Submission ID: S0F6FC794

Proposed Digital Surveys.

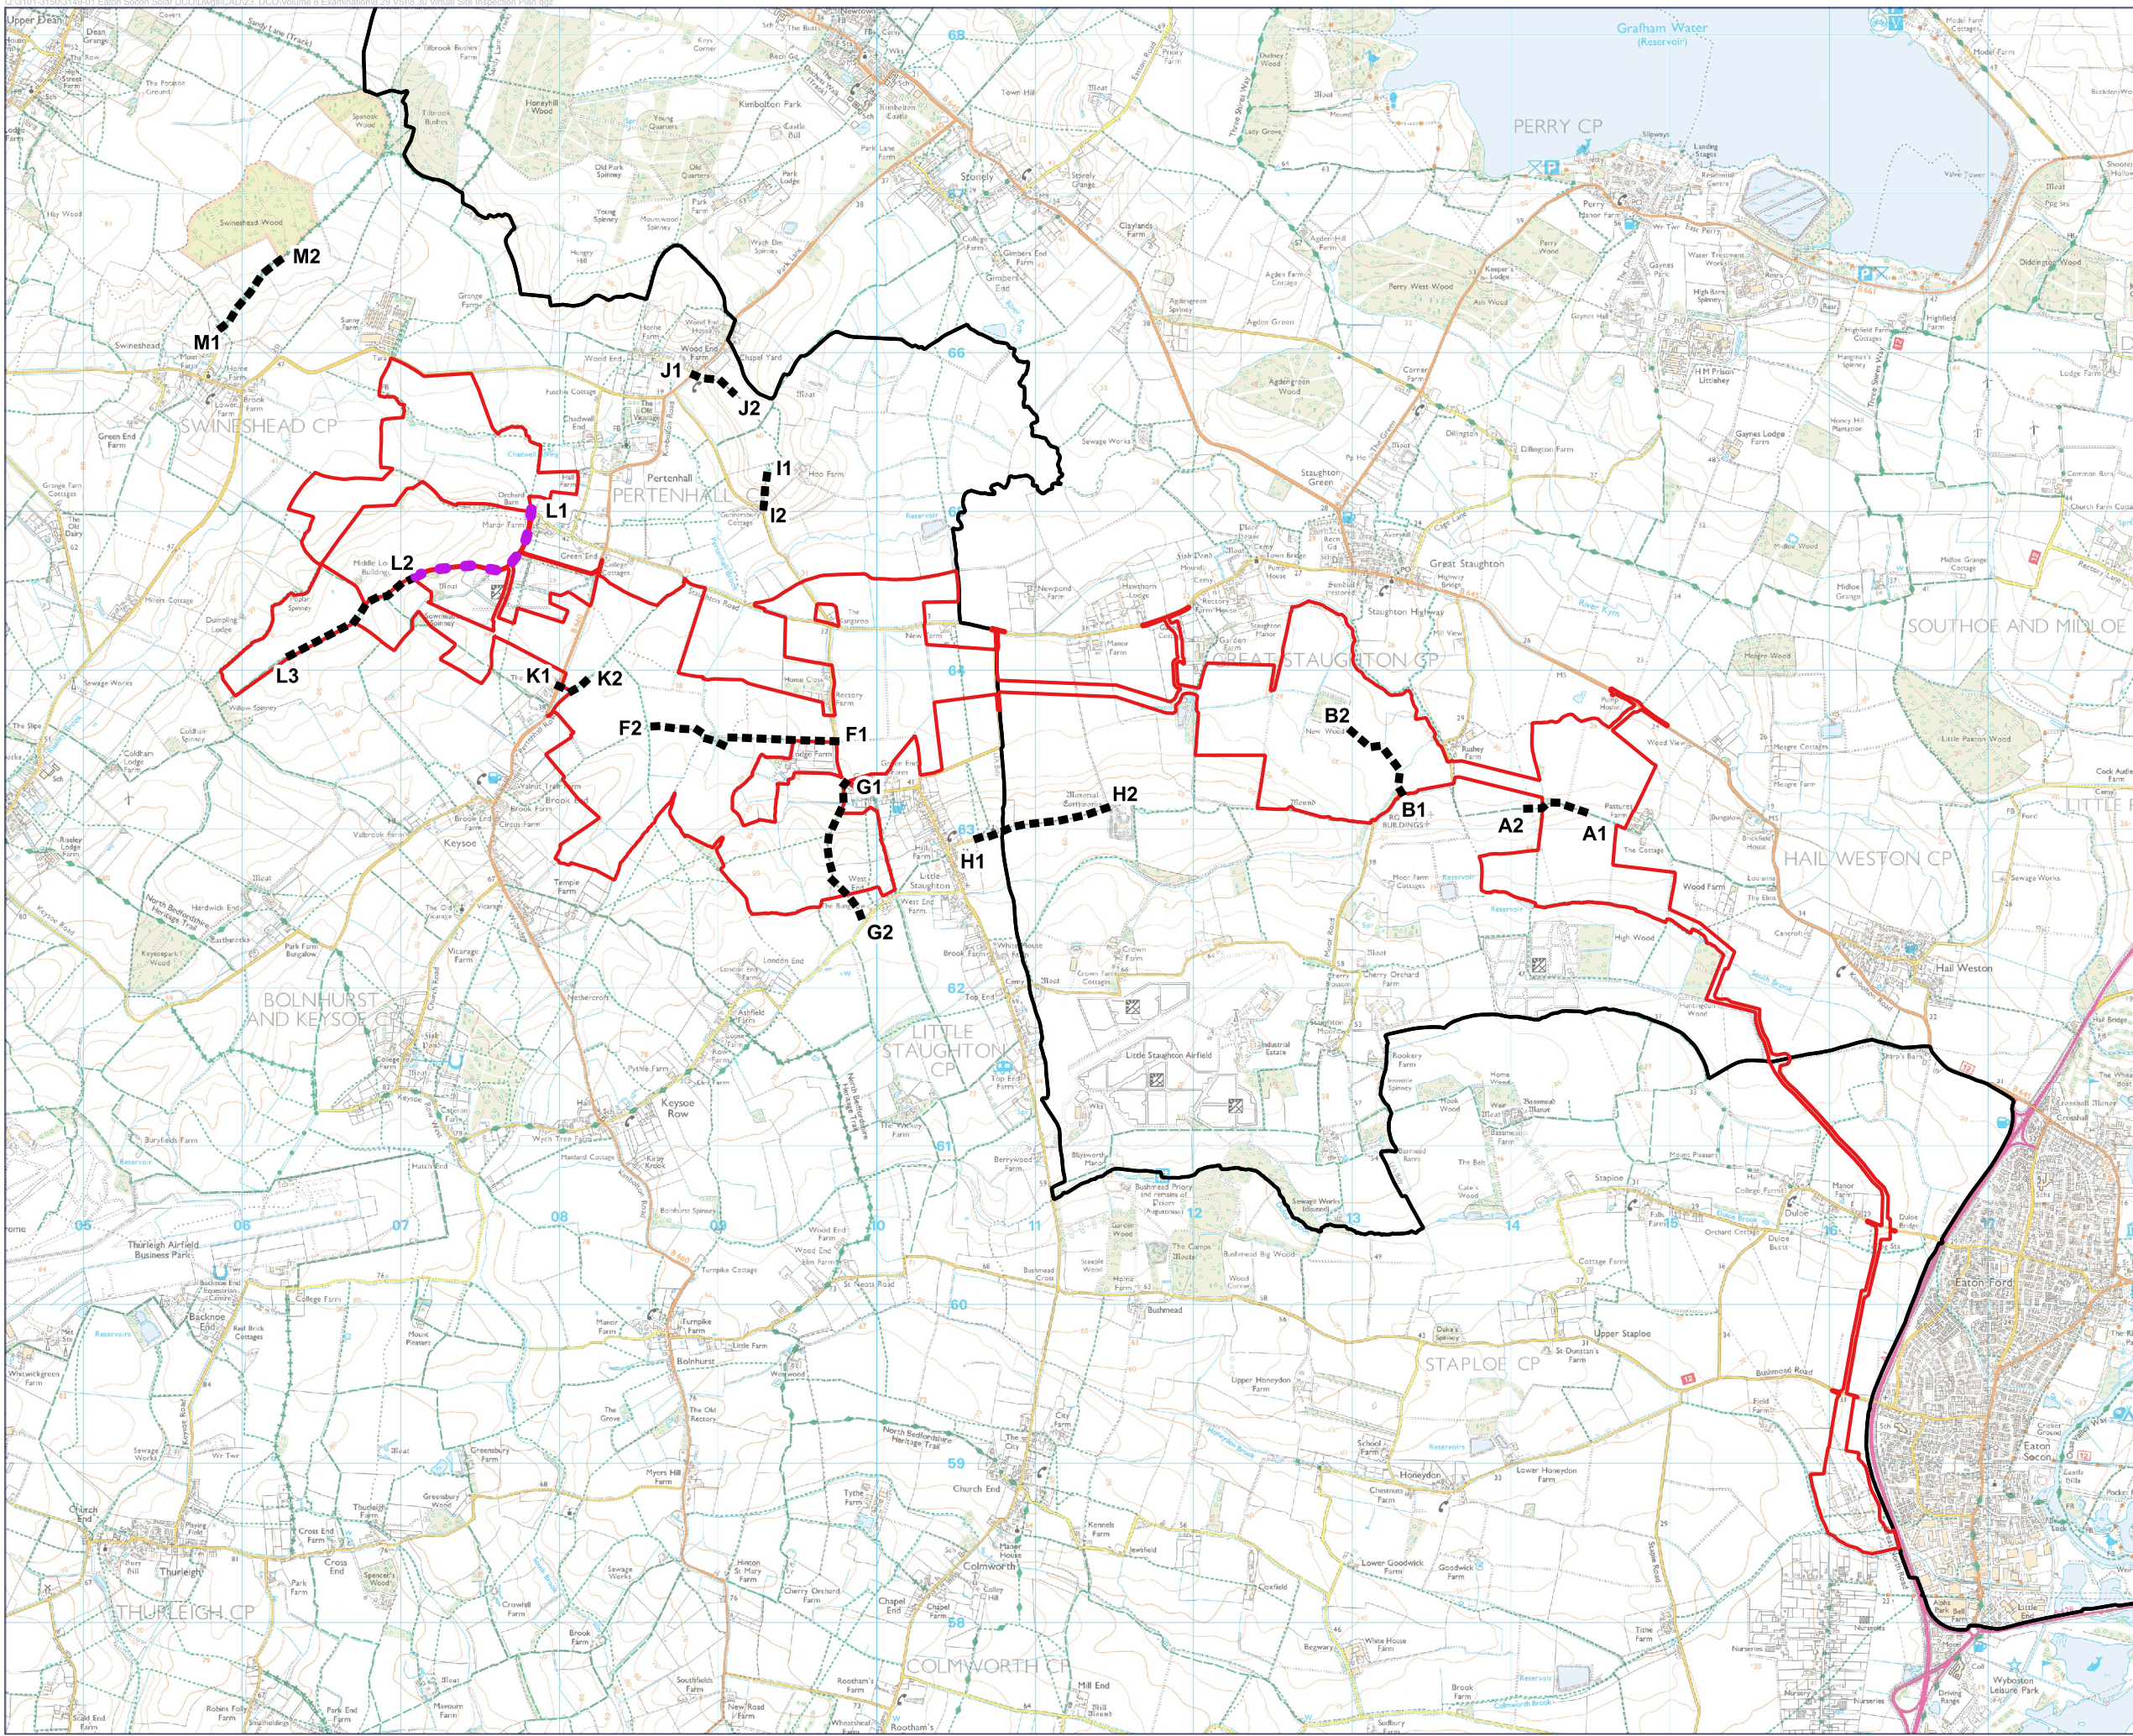
The use of a digital survey of any description instead of an on the ground site survey is not considered to be acceptable. There may however be merits in drone and video walkovers being used in addition to the physical site inspection to refresh the inspector's recall of the site.

Video and drone alone would lose the impact that topography has on this area. The rolling countryside and open spaces gives a unique feeling to the participant. Video and drone and all photography flattens views, not giving a correct feel of the landscape. The enclosed impact on this unique character that this proposal would give will change the area completely and no planting would compensate for this.

This does not show the impact that this would have on walkers and equestrians using the bridleway as it is hard on the BESS compound. The area should also be viewed from the ground to use the footpath up to High Wood which will also show how EPE would join the existing solar installation and one that already has planning permission. Only in person can anyone with a trained eye visualise the environment that would be created.

This route shows how high the area is looking down over the site. This would be lost with cameras minimalising the impact that would be made.

This area needs to be visited, it is at the crossroads. Heading towards Pertenhall the site is flat and very visible from the road. It is also a shared access with a sheep farmer.

It is already fenced on both sides and would make it very dangerous to be shared with an industrial use, especially with additional and higher fencing. A site visit by the Inspector is essential.

This is a steady slope from G1 – G2 with expansive view across the countryside. The impact requires an on-the-ground experience.

This is along the ridge and the views from further along towards the Moat give a greater indication of how the area would be demoted in value.

This area gives a reduced view as that from J1 –J2 looking down towards the Great Staughton Road.

This needs to be extended and walked in person. From here is a view from Birds Egg Farm, across Site A showing how the panels are proposed to go up the lower slopes of the facing ridge, showing how it sweeps behind St Peters church, down towards Green End, Great Staughton Road and the B660 down to Keysoe. It shows how the Brook and the footpath would be entrapped by fencing and panels Only the human eye would show the impact of this and also the proximity to rural houses, several of which are of modest size.

This is not long enough and again requires on the ground presence, at present this is a relaxing walk for pedestrians away from vehicles on B660 on a grassy footpath. It is the route of the sewer, a consideration for the proposed use of so many HGVs.

Video and drone imaging not suitable for this area . It requires walking for the impact of how these dwellings are sandwiched both from front and the rear to be truly appreciated. It is also a habitat of a protected species.

Walking across footpath 35 will also show the poor hedgerow growth of Manor Solar and the tunnel affect it has on experiencing a once open space.

There are very limited views of the proposed EPE site from here.

Additional Viewpoint of Importance not mentioned Footpath 14 leading from Wood End Lane.

This footpath rises steeply and prior to reaching the hedgerow crossing the site into Cambs. The Inspector should turn and look back the viewpoint will show a very visible site from Birds Egg Farm, rising upwards to the ridge of Middle Lodge and round towards St Peters church. This is a well used route both by locals and walkers coming to the area.
